18 January 2018

NELSON BAY ROAD (B63): MAJOR PROJECT MP07/0094 MOD 4, SALT ASH QUARRY PROJECT, LOTS: 632 & 633 DP: 609506 AND LOT: 4042 DP: 609506, 7 JANET PARADE, SALT ASH

Figure 4 | Location of Nelson Bay Road/ Janet Parade intersection

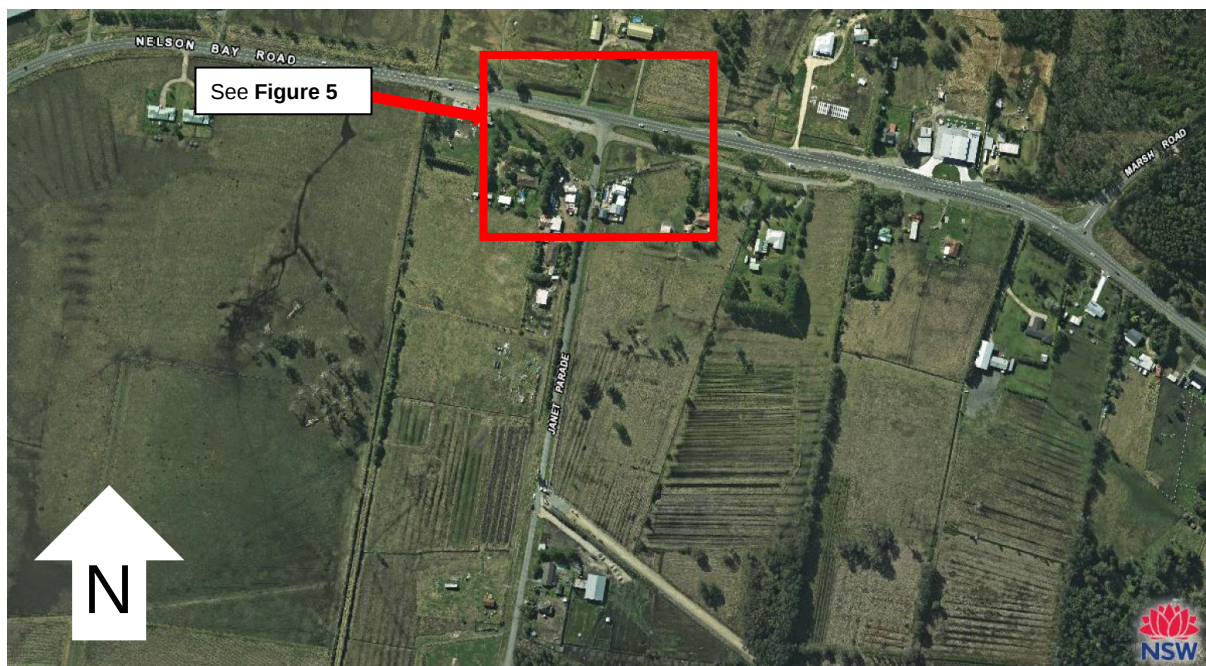
- The intersection of Nelson Bay Road and Janet Parade shall be upgraded to comply with the intersection warrants within Section 2.3.6 of *Austroads Guide to Traffic Management Part 6: Intersections, Interchanges and Crossings*.

Comment: Based on the information provided within the SECA Solutions Traffic Impact Assessment dated October 2017, including:

- o *Design speed = 90kph,*
- o *>10 movements in AM peak period (includes existing traffic generated by development in Janet Street and proposed traffic generated by quarry), and,*
- o *Daily traffic flow of >12,000 vehicles (c. 2017) and up to 16,200 vehicles by 2027*

the intersection treatment warrants an upgrade to include a channelised-right turn / channelised-left turn (CHR / CHL).

Roads and Maritime are also acutely aware of the need to ensure new development, specifically development generating heavy vehicle movements, does not compromise the safety of the classified network. SECA's traffic assessment identifies that westbound through traffic already comprises of a high number of heavy vehicle movements (almost 1 per minute in the AM peak) which reduces the number of opportunities for right-turning vehicles into Janet Parade and increases the likelihood of queuing vehicles on Nelson Bay Road. A channelised-right turn treatment serves to protect the stationary right turn vehicle, prevent the incidence of rear end collisions, and promote a clear lane for through vehicles to pass.
